**Summary of Oral Submissions -
Messing & Inworth Action
Group Limited**

The following are summaries of the oral submissions made by Stephen Humphreys of Ashfords LLP - on behalf of Messing and Inworth Action Group Limited (MIAG) - at the A12 DCO Preliminary Meeting and Open Floor Hearing on 12 January 2023.

Map Book 4: B1023 Flood Mitigation and Drainage

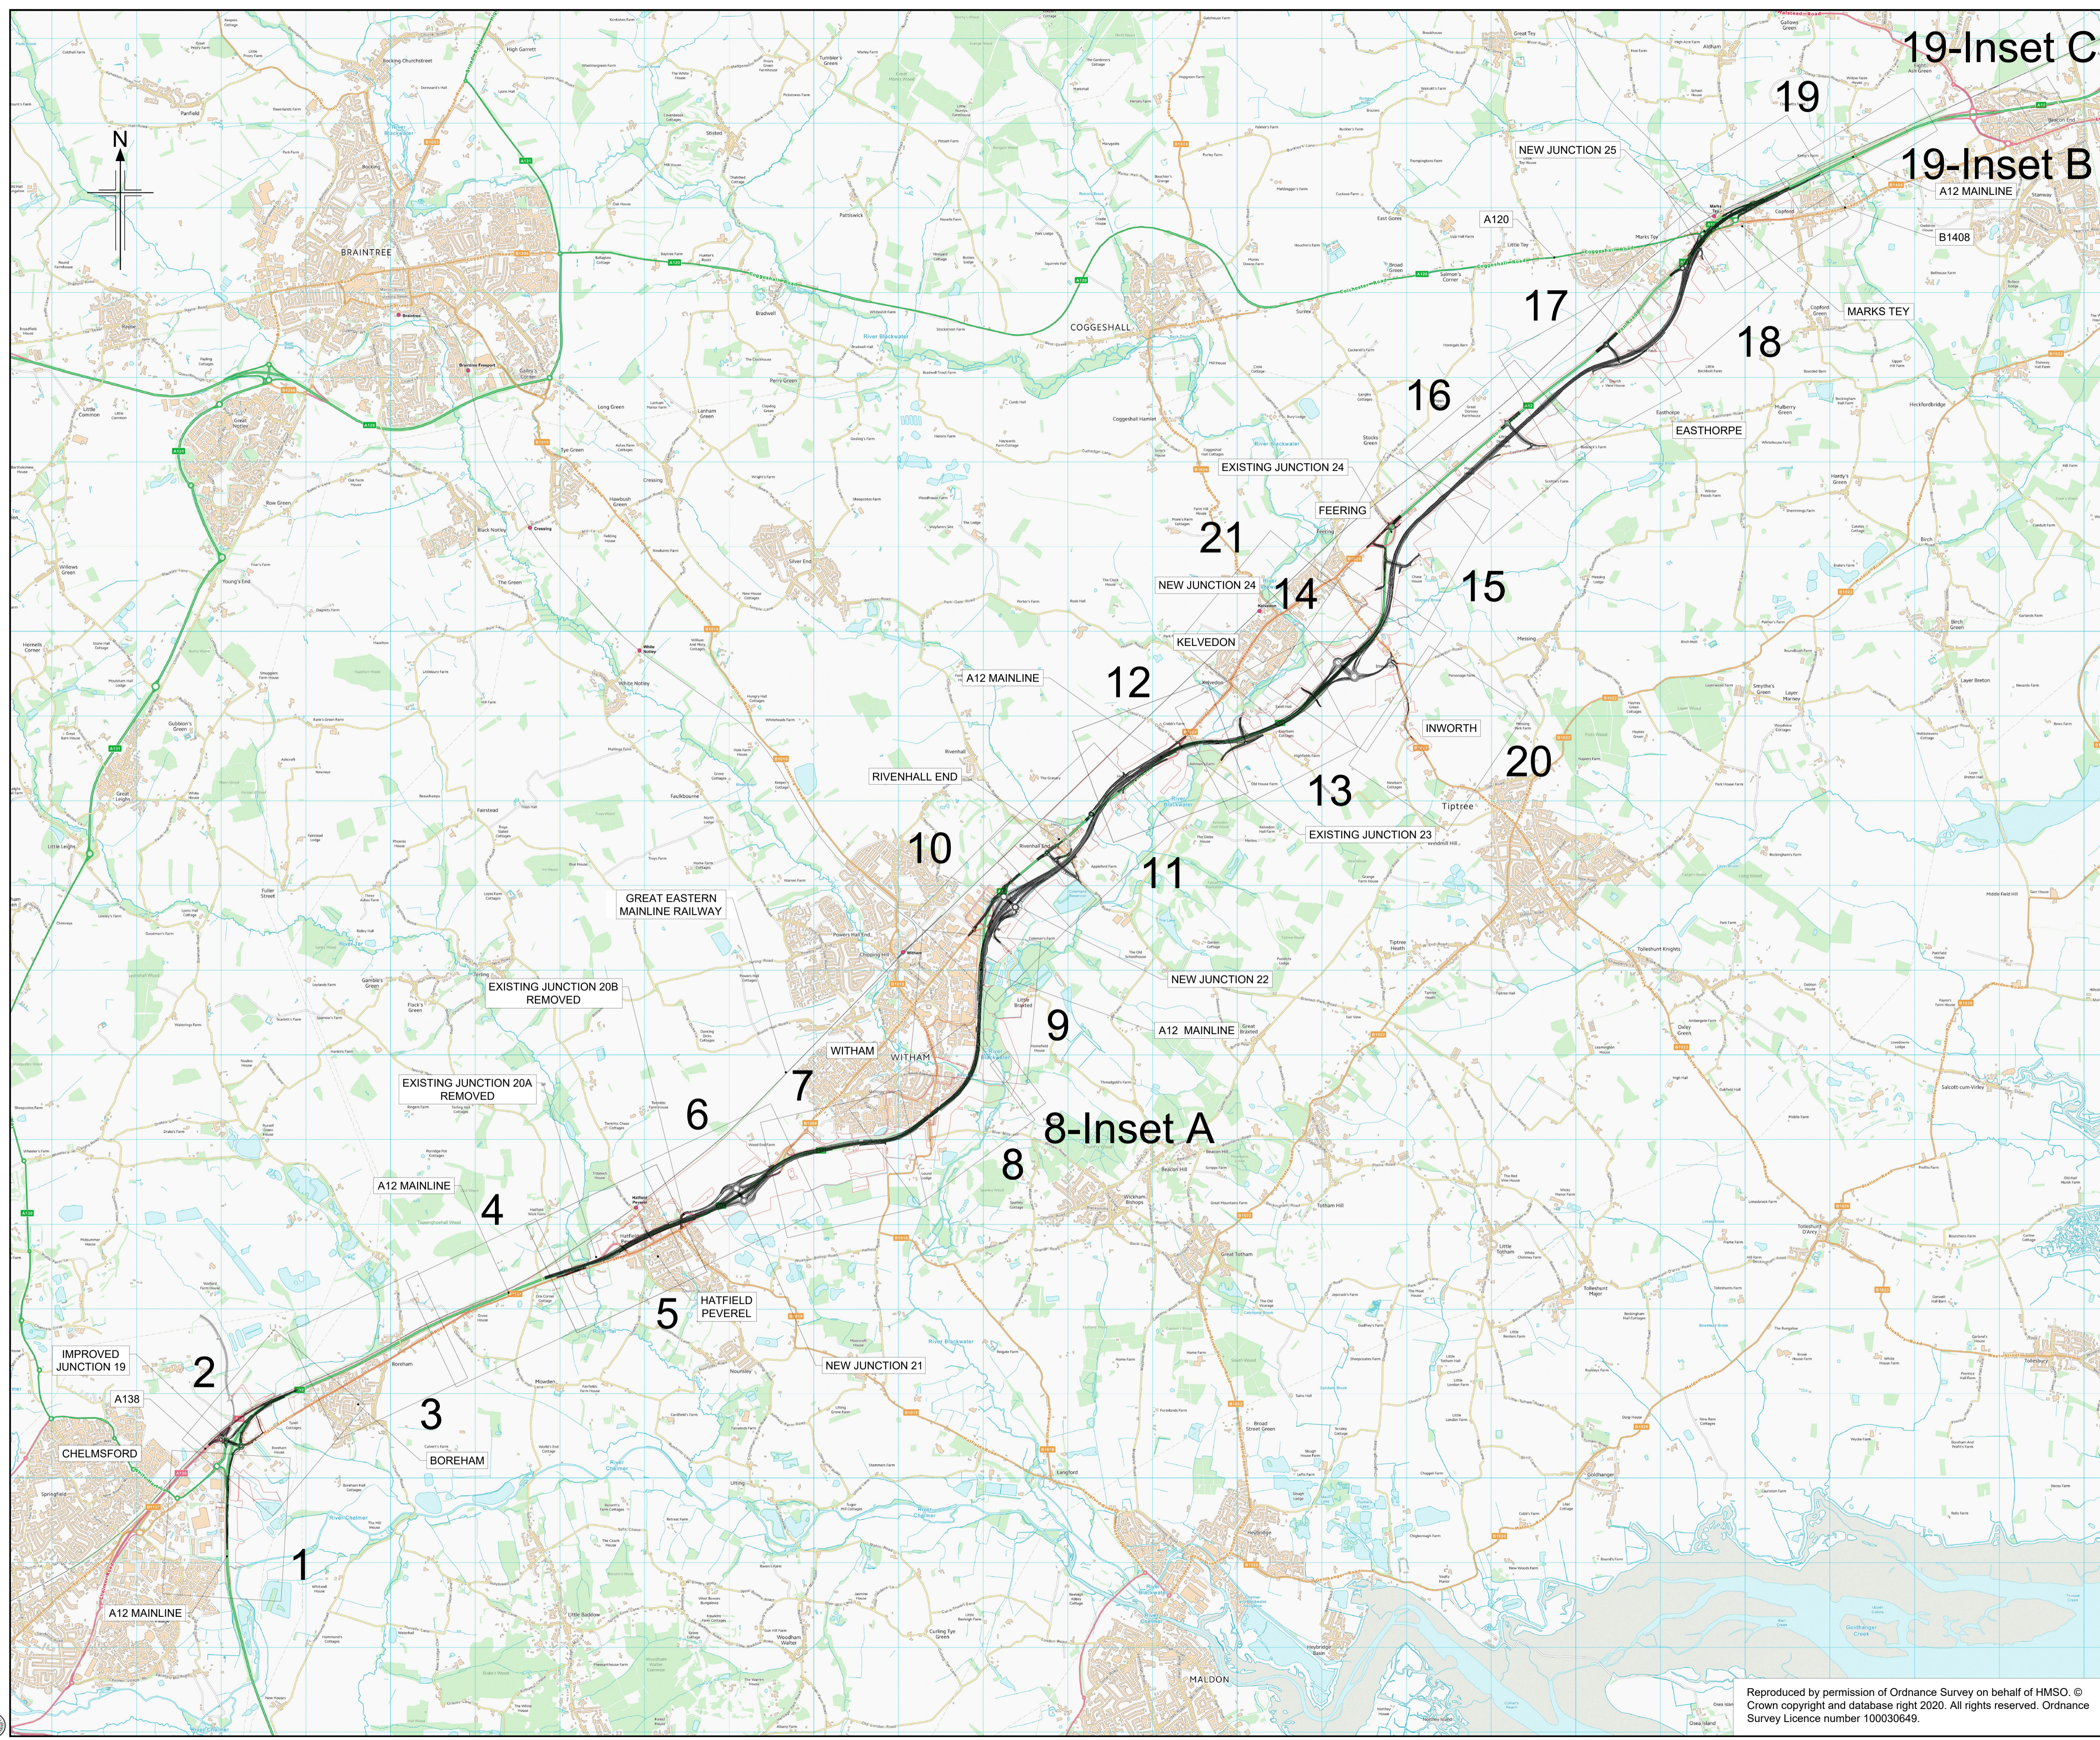
6. Flooding on the local roads is a concern for MIAG and details of this were provided to NH as part of the consultation exercise prior to submission of the scheme. Both Inworth Road and Kelvedon Road experience surface water flooding. These impacts need to be addressed by NH as part of the scheme.

Map Book 5: B1023 Roundabout

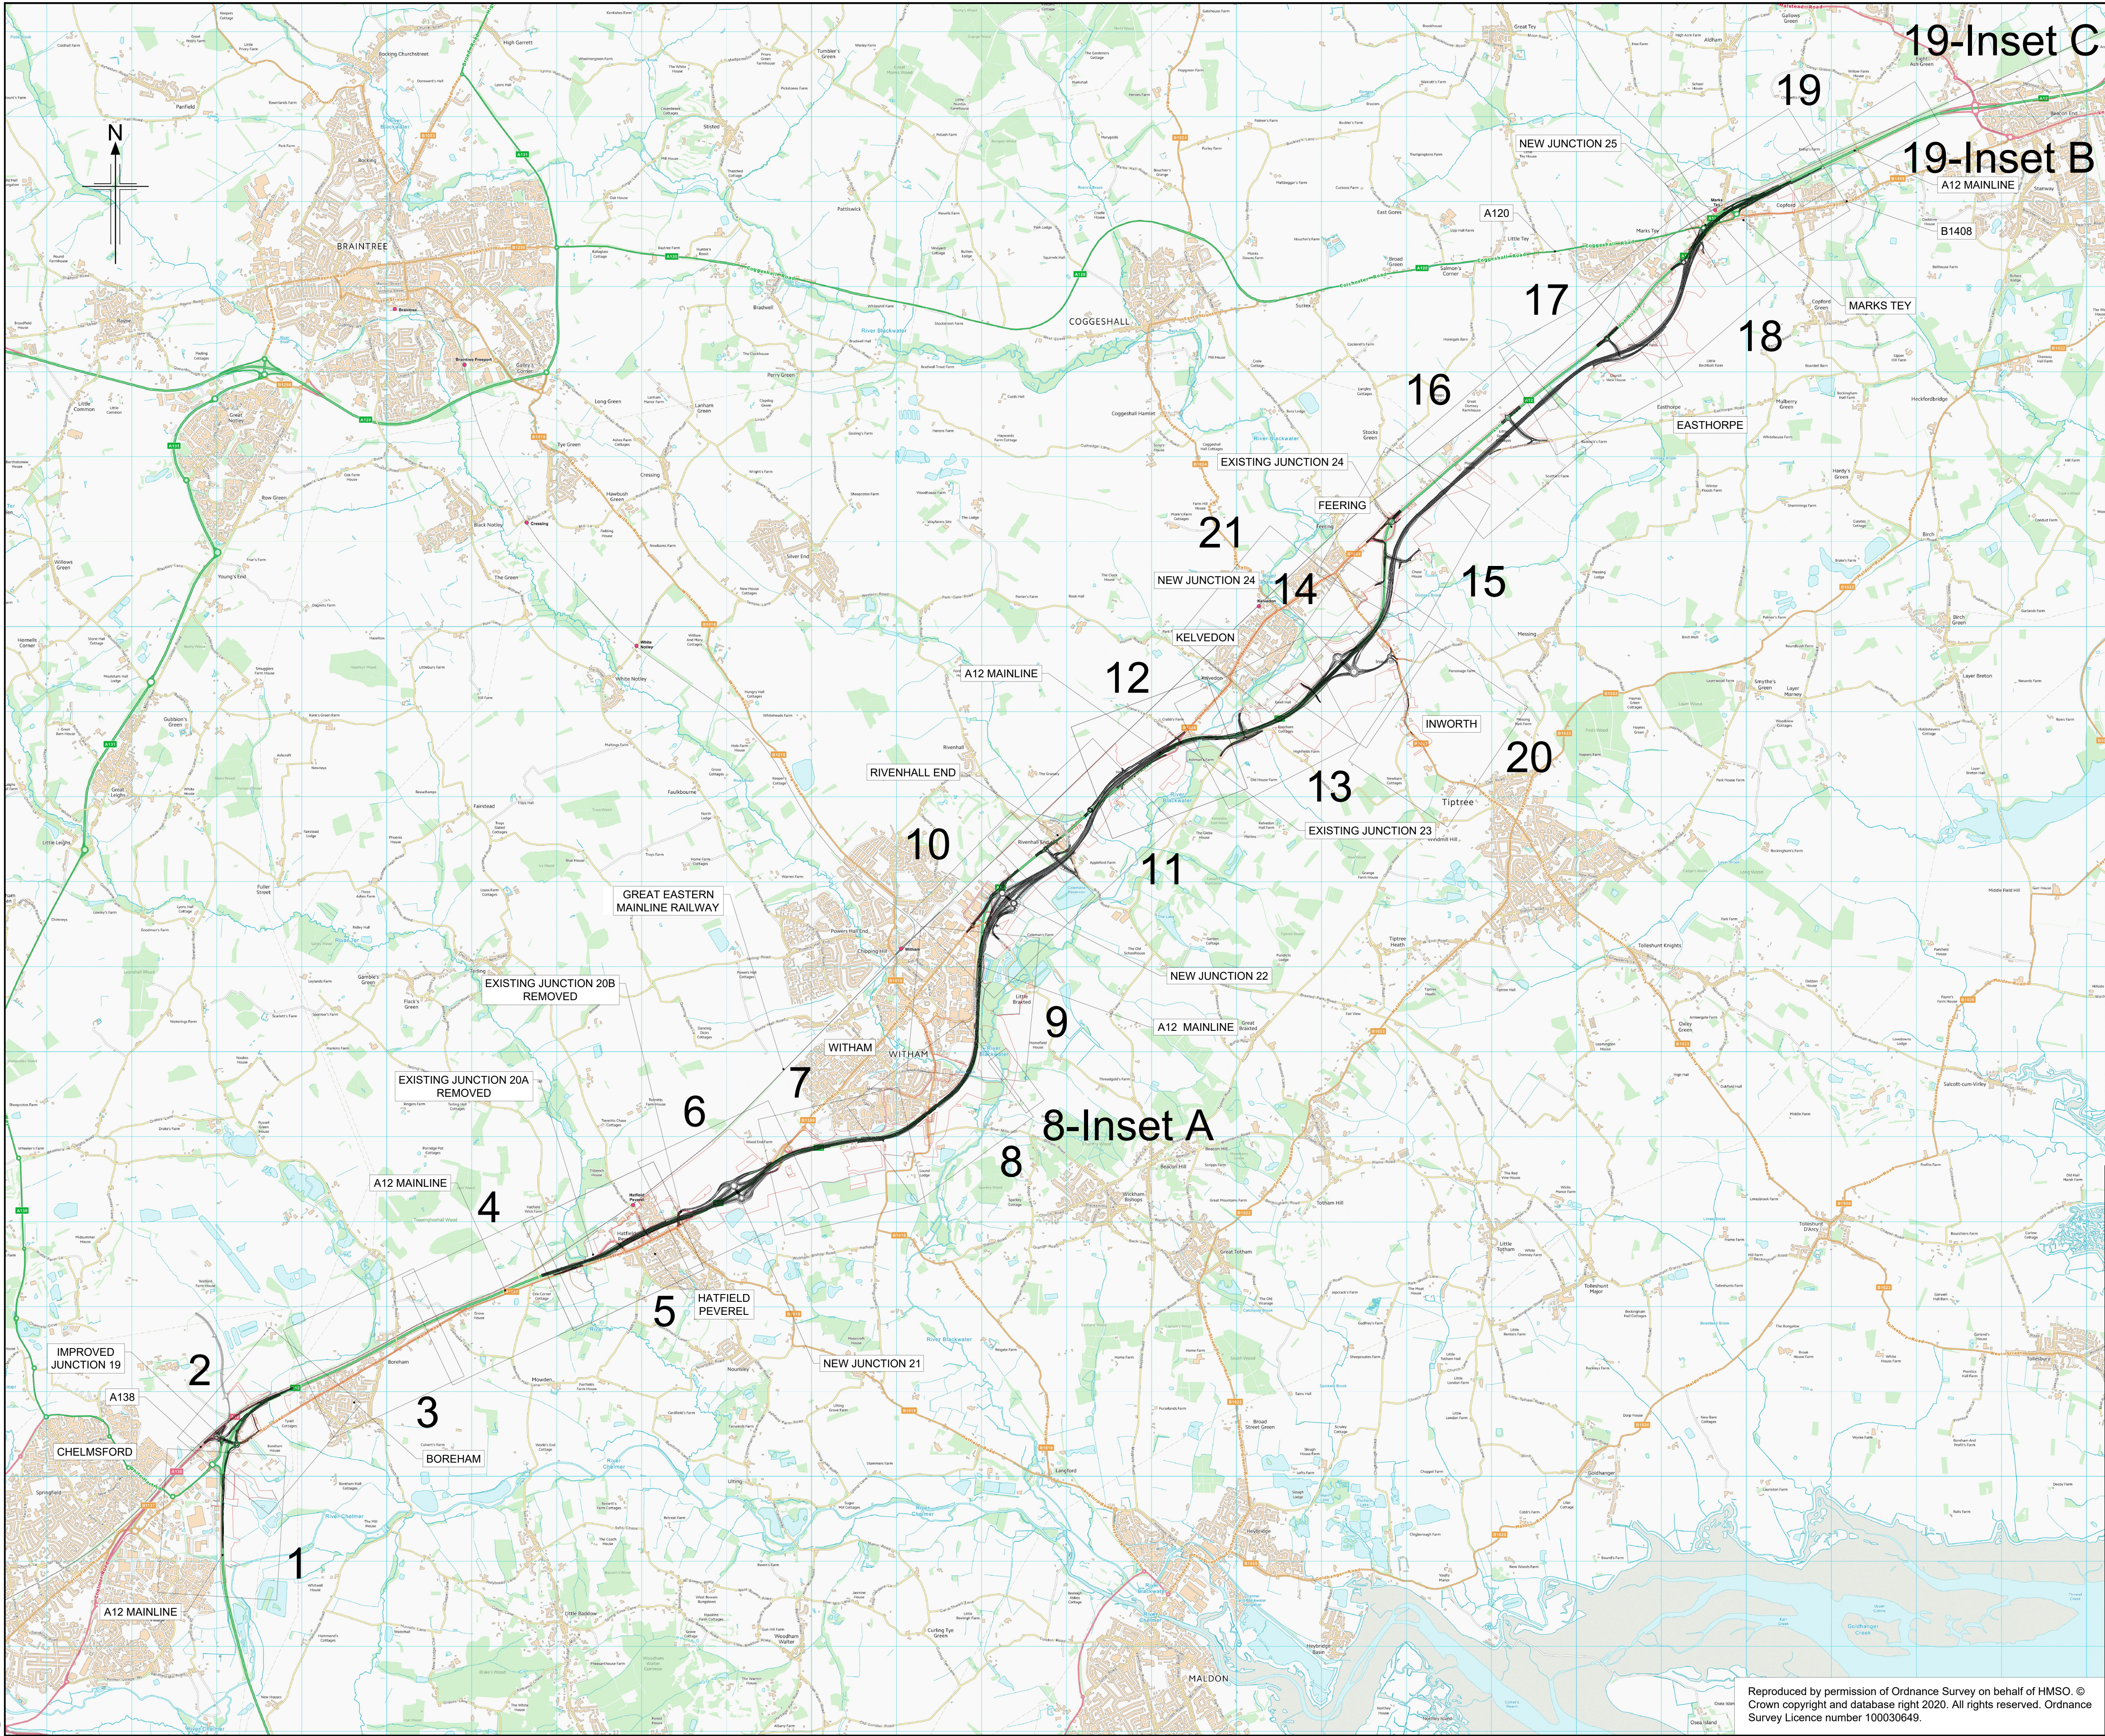
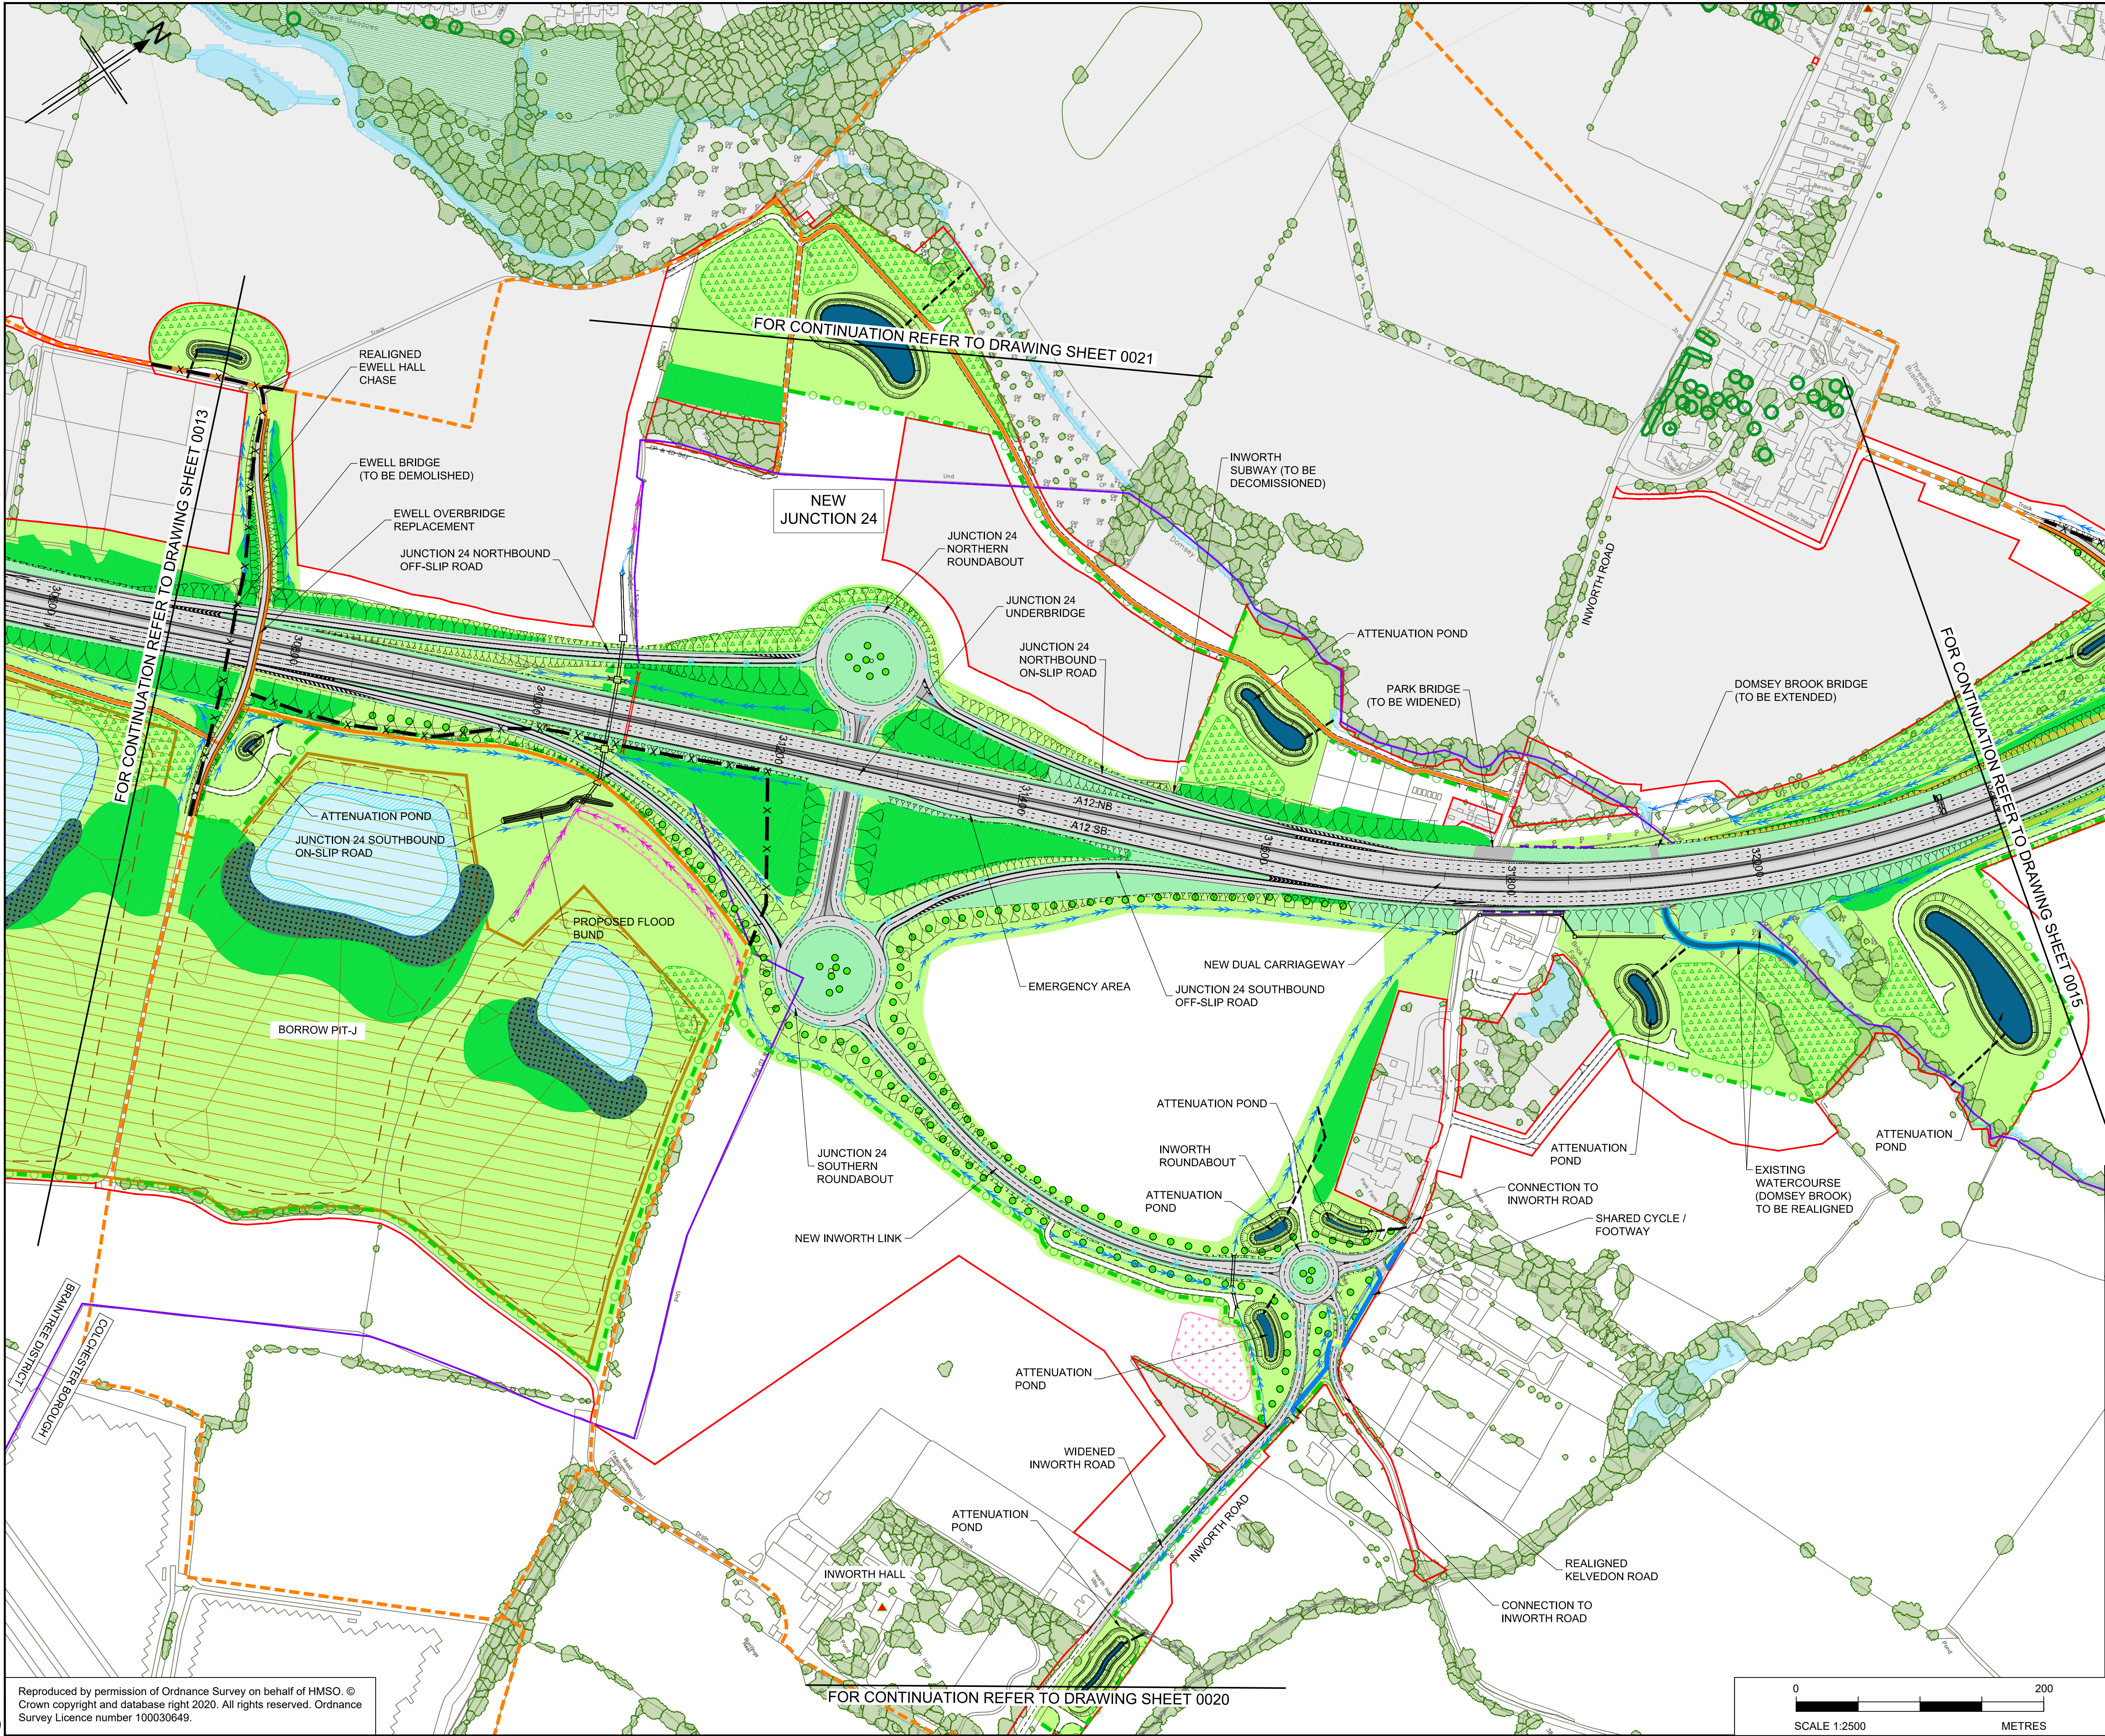
5. MIAG has concern with the design of the B1023 Inworth Road Roundabout, including its adherence to design standards. This point will be picked up in more detail in MIAG's written representation.
